Our Ref: LM/ARU/21/17C

Date 22nd December 2021

RE: Phase 5 Hampton Park Toddington Lane Littlehampton BN17 7PL

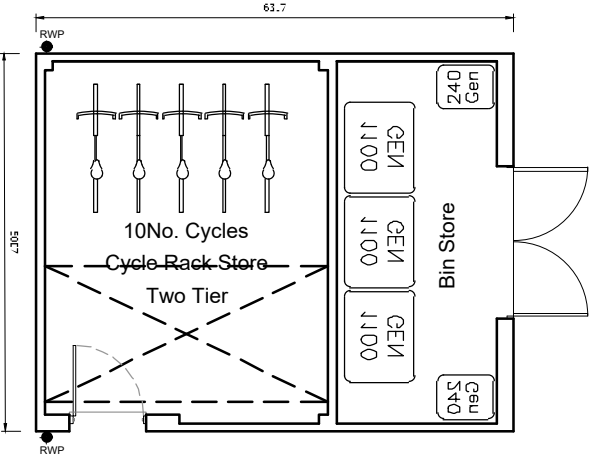
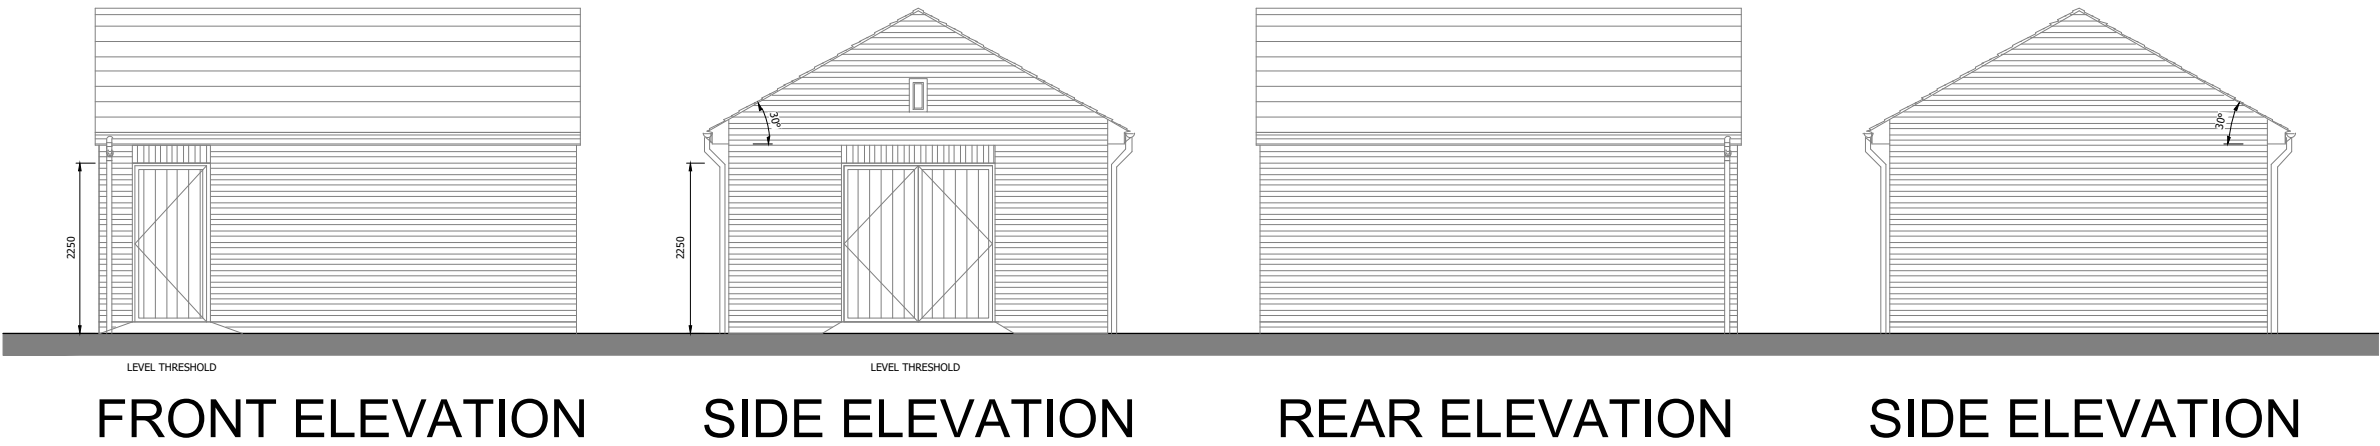
With regards to cycle stores within the development - research by the 'Design against Crime Centre' suggests that cyclists should be encouraged to lock both wheels and the crossbar to a stand rather than just the crossbar and therefore a design of cycle stand that enables this method of locking to be used is recommended. Minimum requirements for such equipment: • Galvanised steel bar construction (minimum thickness 3mm), filled with concrete; • Minimum foundation depth of 300mm with welded 'anchor bar'. Given that modern cycles have numerous quick release components - to reduce the pay-off to any would be offender it is recommended that no more than 30 cycles be stored within a communal cycle store.
